From: Sarah Burrow <Sarah.Burrow@arun.gov.uk>
Sent: 24 June 2022 12:08
To: Planning.Responses <Planning.Responses@arun.gov.uk>
Cc: Amber Willard <Amber.Willard@arun.gov.uk>
Subject: RE: Planning Consultation on: Y/60/22/PL

Engineers Comments Regarding Surface Water Drainage

Registered: 10th May 2022
Site Address: Longacre Maypole Lane Yapton BN18 0DR
Grid Reference: 497782 104127
Description of Works: Erection of 1 No detached dwelling and garage with shared access from Maypole Lane. This application is a Departure from the Development Plan and this site is in CIL Zone 3 and is CIL Liable as a new dwelling.

7.1 Appendix A – Site Plan

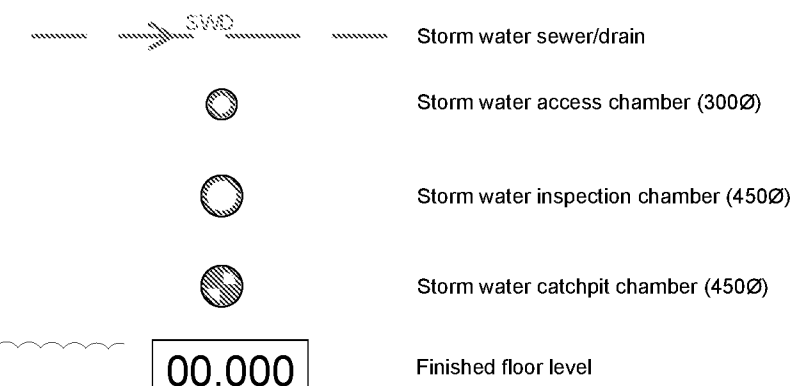
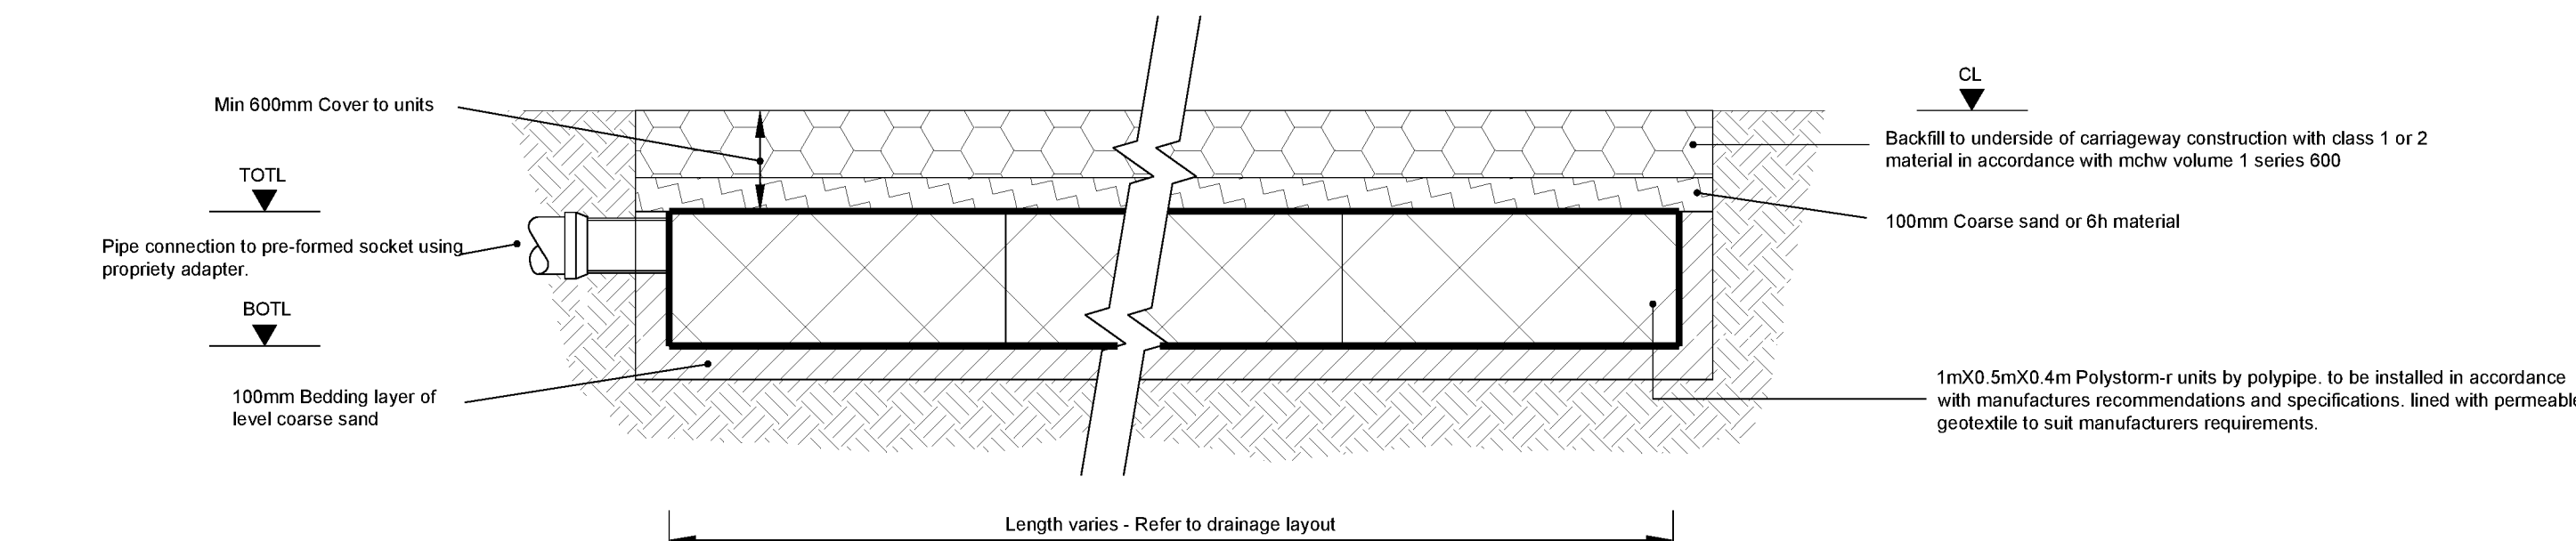
1. The manufacturer specific details for the Polystorm R crates should be included within the design package.
2. The incoming pipe invert level is not given, this must be set above the critical 1 in 10 year +40% event and shown on the drainage layout.

3. Inspection chambers and silt traps are shown after bends in the pipes. Please ensure these are located on the junctions to remove pipe bends.
4. No detail for the self-draining permeable paving is included. Please show the construction detail for this, including the formation depth.
